17/06869  
SSD 8448

**State Significant Development – Secretary's Environmental Assessment Requirements  
Elgas Storage Facility – 130 Cormorant Road, Kooragang (SSD 8448)**

#### **APPLICATION FOR SEARS FOR ELGAS LPG STORAGE FACILITY KOORAGANG**

Project
ELGAS STORAGE FACILITY
Part Lot 1 DP 1195444 - CORMORANT ROAD Cnr. EGRET STREET
KOORAGANG NSW
FOR
SOVECHLES NOMINEES Pty Ltd
Drawing Title
LANDSCAPE SITE PLAN

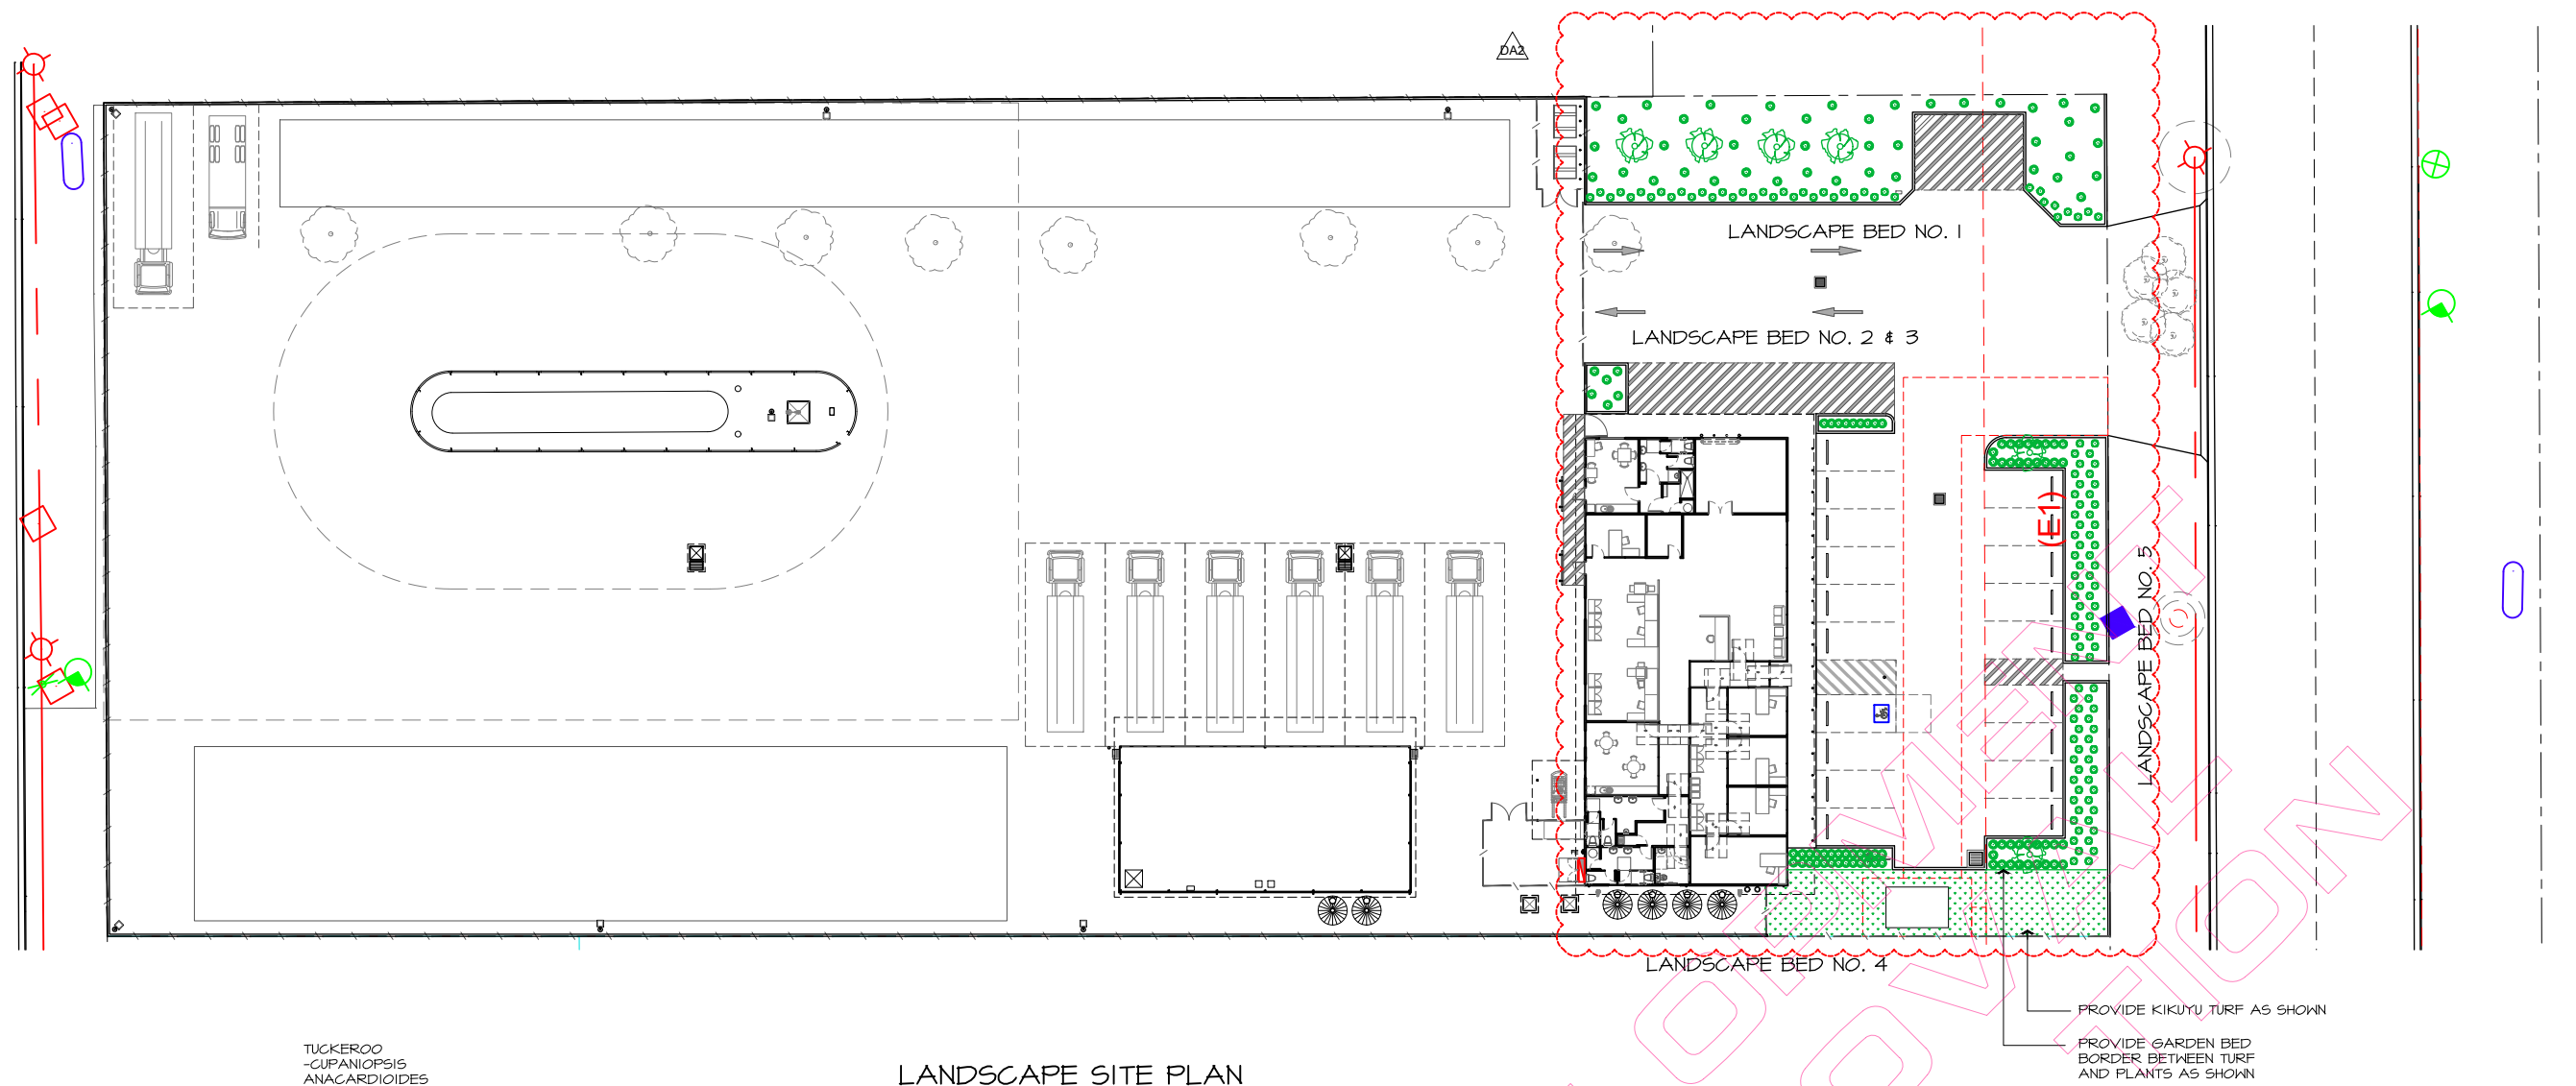
- providing details of the compensatory trees proposed across the Egret Street frontage of the site to offset the removal of the existing trees.

TURNING STUDY - DELIVERY BAY - 12.5m RIGID
MANOEUVRE ONE - DRIVE INTO TURNING BAY

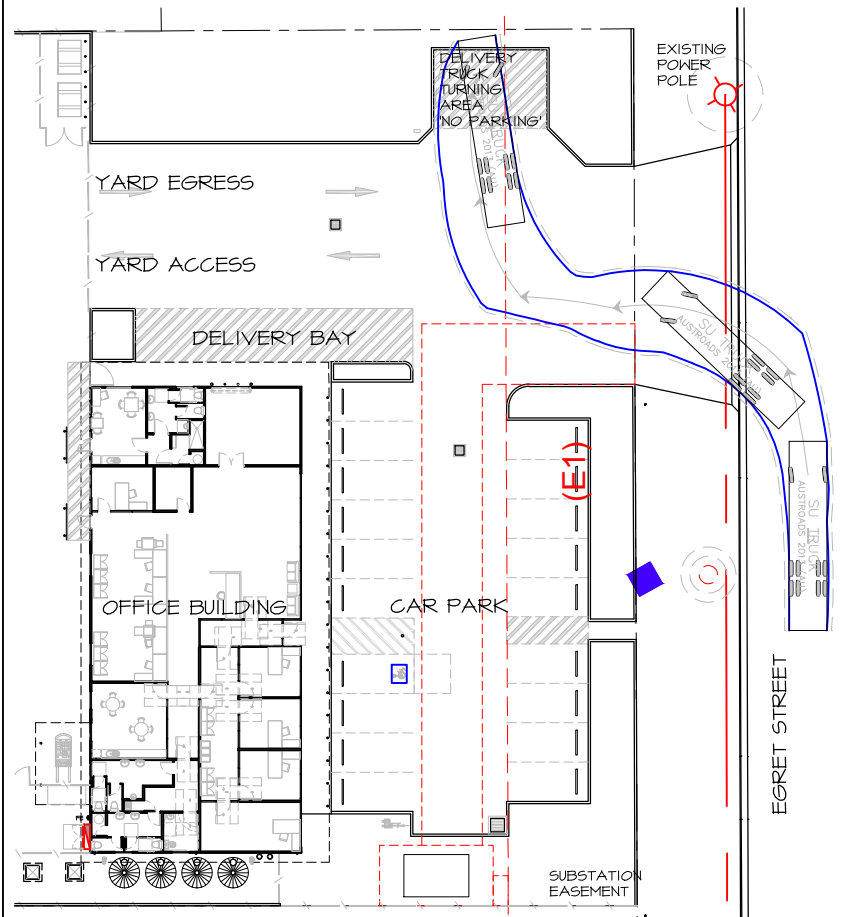
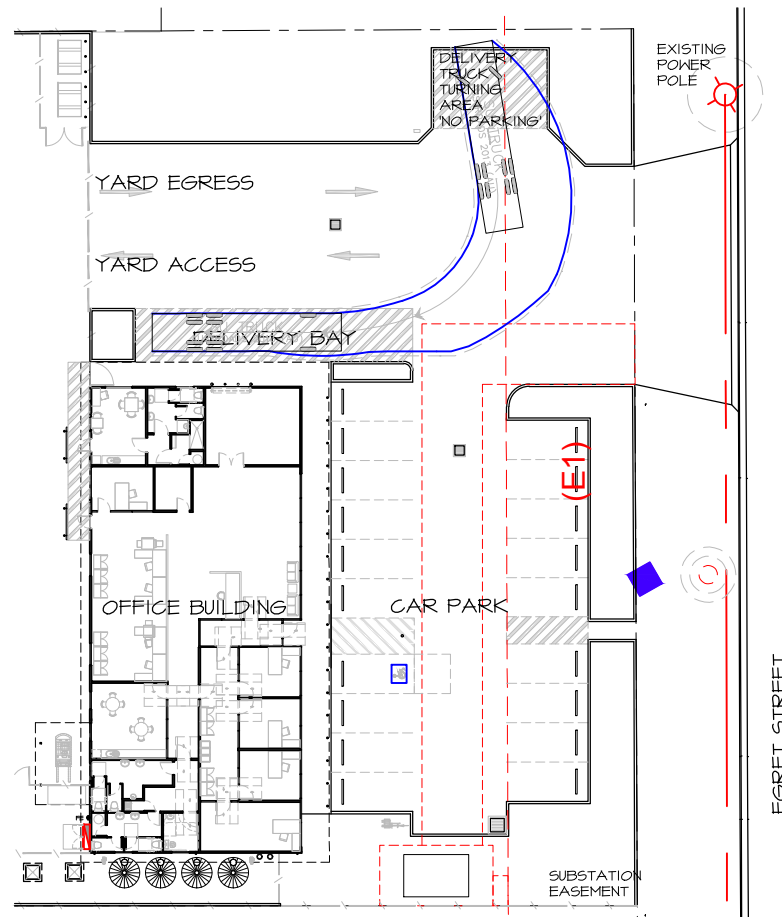
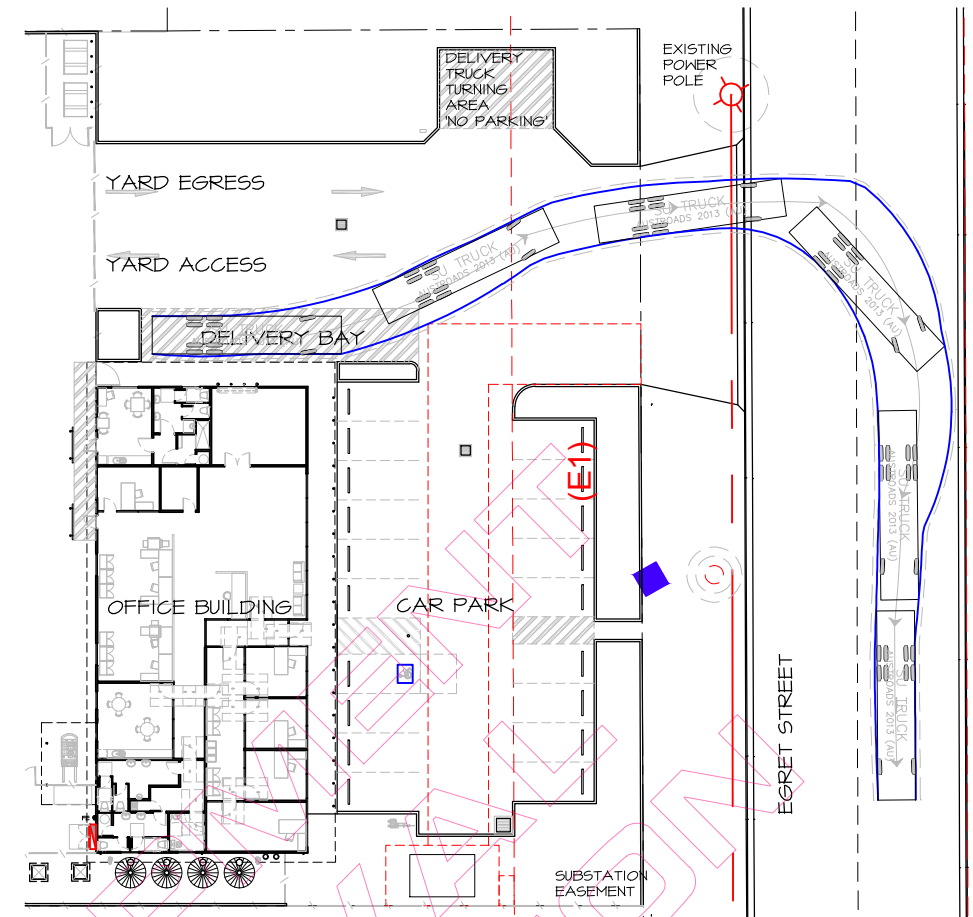
- consideration of potential vehicular conflict between vehicles using the loading bay and car entering and leaving the car park.

General comment: Significant safety concerns are raised in relation to the location of the proposed delivery bay relative to the car park entry /exit and potential for vehicle conflict. In this regard, it is recommended that the delivery bay be relocated to within the site.
